OXFORDSHIRE COUNTY COUNCIL'S RESPONSE TO CONSULTATION ON THE FOLLOWING DEVELOPMENT PROPOSAL

Application no: 21/02339/REM

Proposal: Reserved Matters application for 14/02121/OUT, Phase 1 Development of 500 dwellings, landscaping, new vehicular, cycle and pedestrian access routes and other operations

Location: Proposed Himley Village North West Bicester, Middleton Stoney Road, Bicester

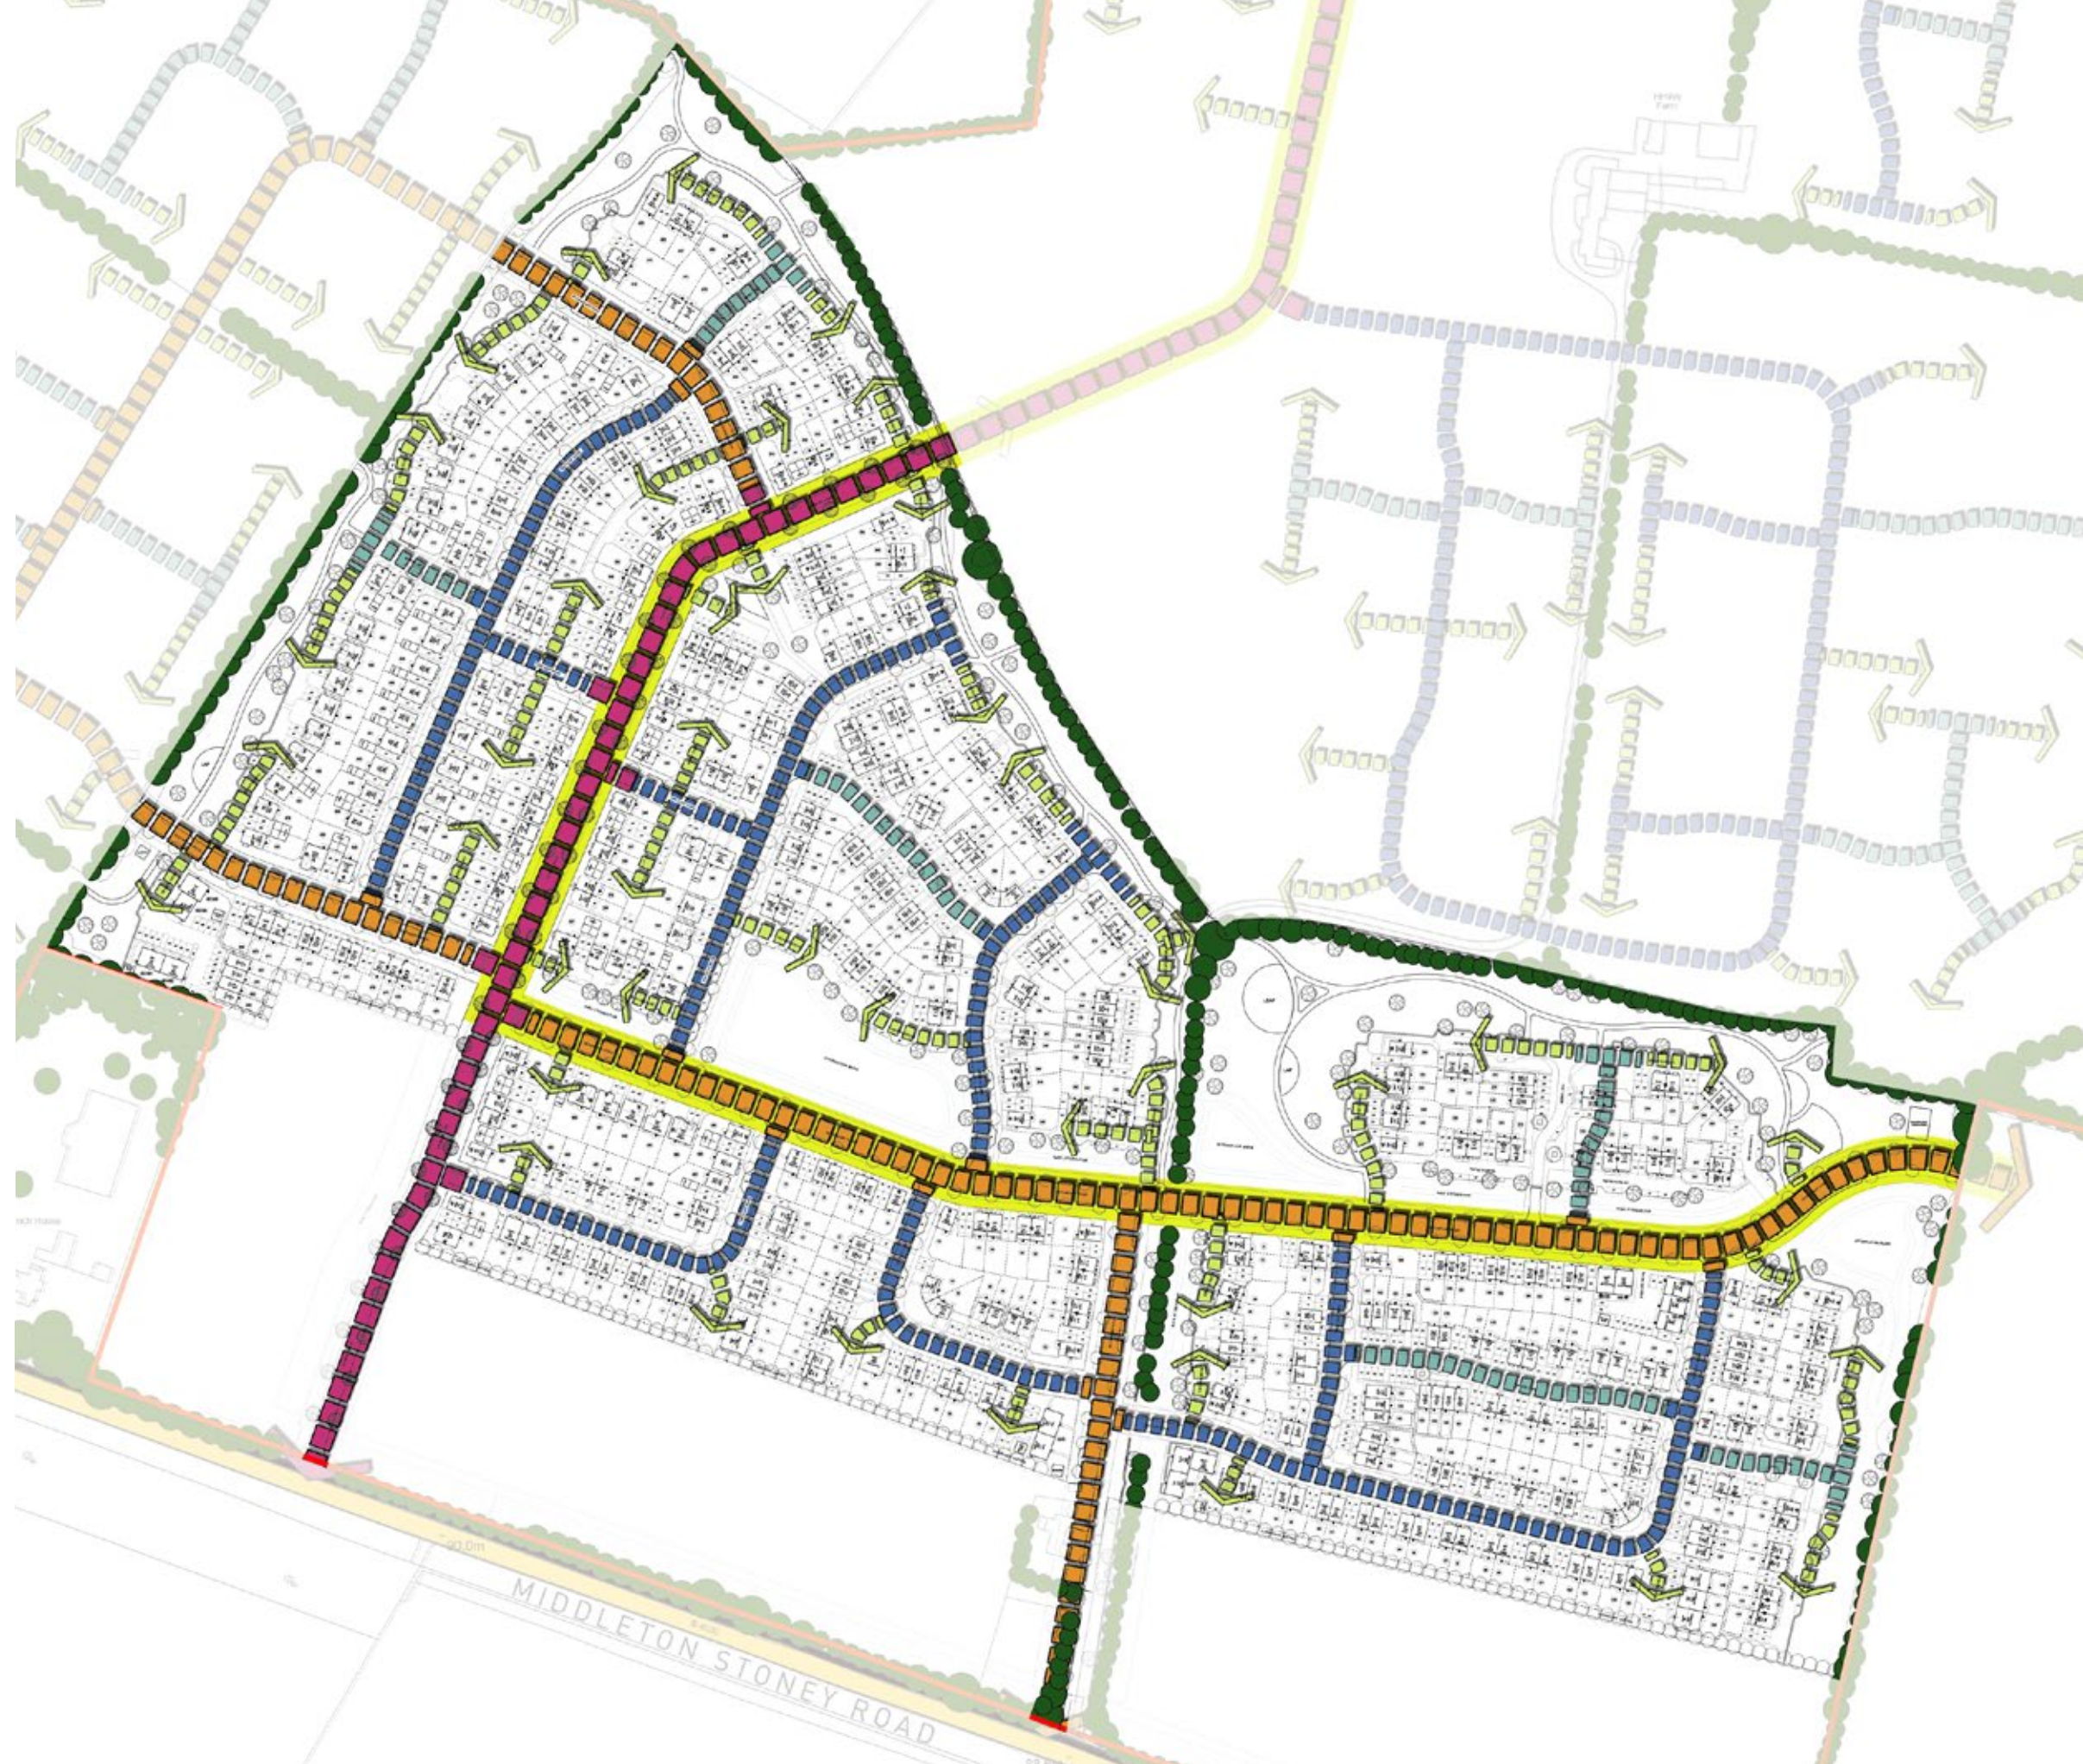
It will therefore be of crucial importance for the sustainability of the development that this service can penetrate into Phase 1 of the Himley development, by utilising both access points from Middleton Stoney Road and the parallel road that connects them. Each of these routes must be of Primary Street width and character in order to enable this to take place.

Whilst the bus service pattern envisaged in the Eco Town Master Plan (with both north and south routes utilising Bucknell Road) is not now considered the most appropriate means of serving the sites by bus, highway connections to adjoining land holdings forming part of the Eco Town are necessary for the final intended pattern of bus access and circulation in the future. The link between the Primary Street to the boundary with Albion, referred to as a Secondary Street within the Design Code, is as important in this regard as the Primary Street.

- No fewer than five bus stops should be provided within the Phase 1 area and on Middleton Stoney Road;
- The Secondary Street linking the two access roads, and the eastern access road itself, must be upgraded to a Primary Street to accommodate two-way bus access; and
- These roads must be kept clear of obstruction through provision of off-carriageway parking bays or double yellow lines.
